9 October 2025

Proposal: Demolition, tree removal, construction of a 3 buildings ranging in height between 7 and 21 storeys and ancillary civil works
Property: 372-374 Mann Street and 35-37 Dwyer Street, North Gosford
Application: SSD-69773460

Rear Loading Refuse Truck

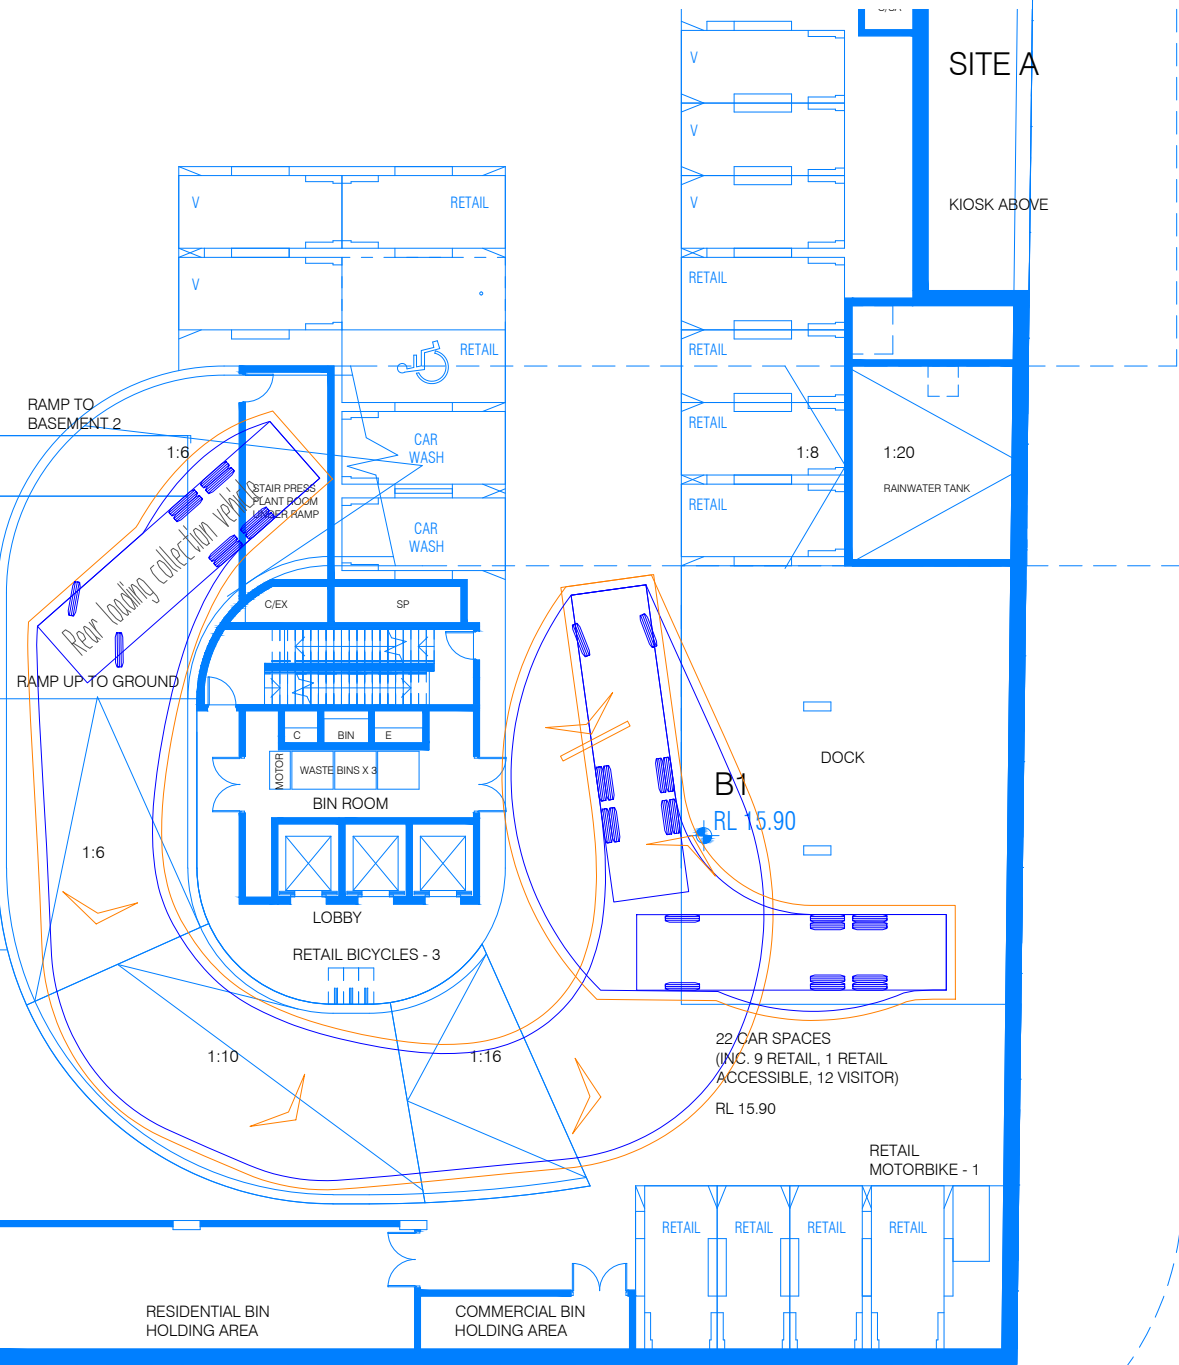
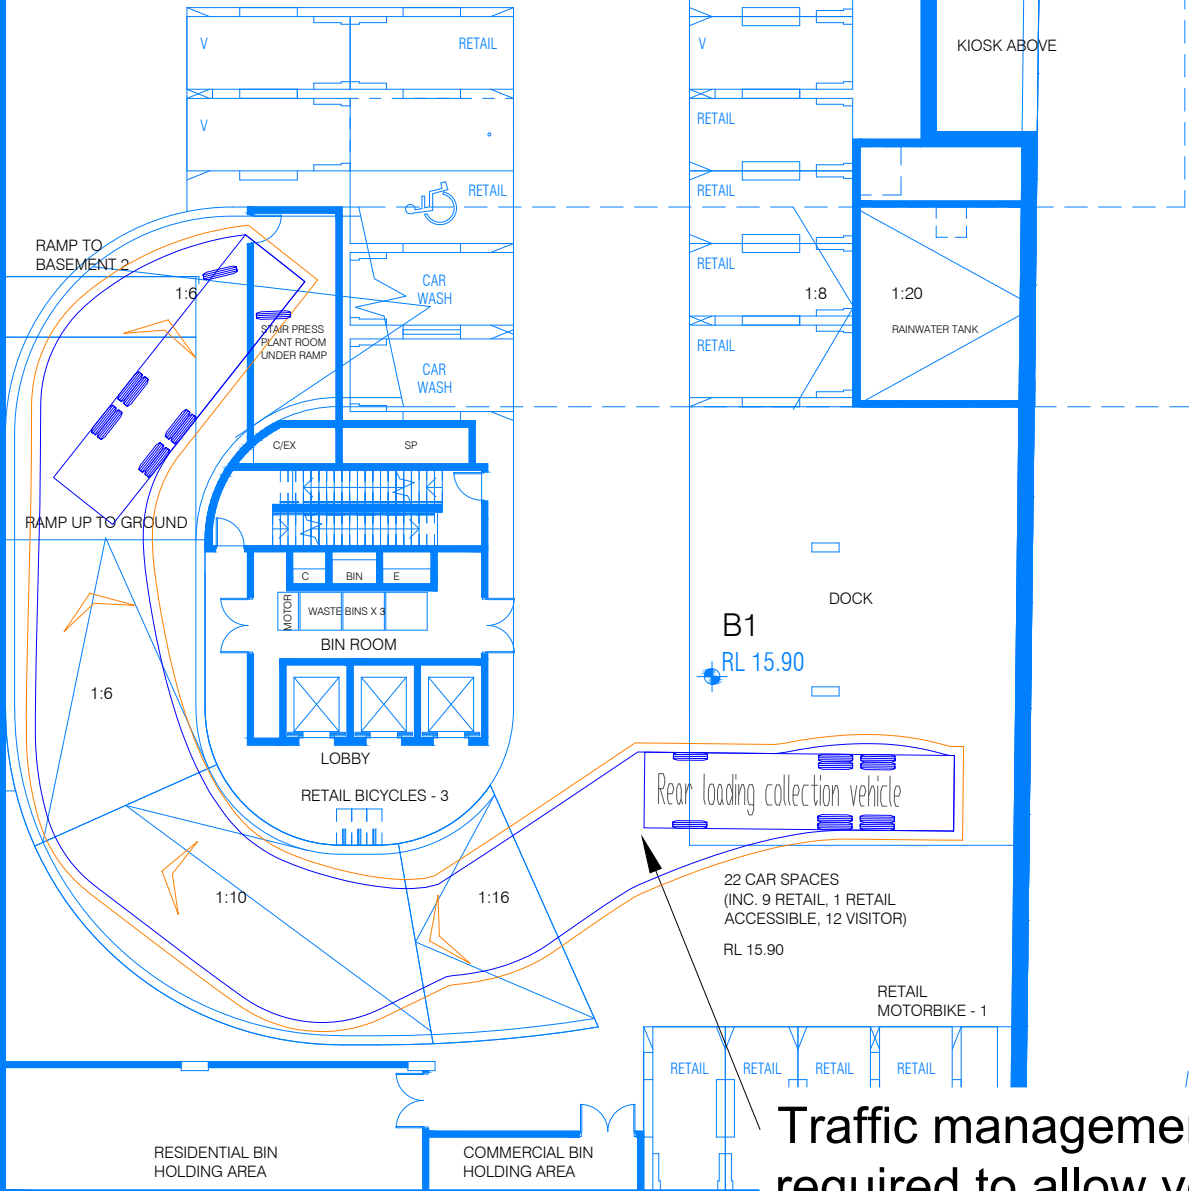
- The TA indicates *Traffic management measures will be necessary at infrequent times when waste vehicles (and other heavy vehicles) enter and exit the basement loading areas. This would include a standard stop/go signal system, with laser detectors set at appropriate height. The vehicle swept paths are included in Appendix C.* Details are to be provided as to where and how this traffic management system will operate.

- The waste truck utilises the majority of the access driveway and ramp areas to enter and exit the site, thus removing opportunities for vehicles to pass. It is unclear where vehicles can 'stop' to enable clear travel paths for the waste service vehicle, and if the proposed traffic management system will result in queueing in Dwyer Street. Queueing of vehicles in Dwyer Street associated with vehicles potentially waiting to enter the development from Dwyer Street will not be supported by Council.

- With due reference to the vehicular swept turning paths provided in the TA, Council does not support the waste service vehicle obstructing the parking/circulation aisle area when servicing waste.
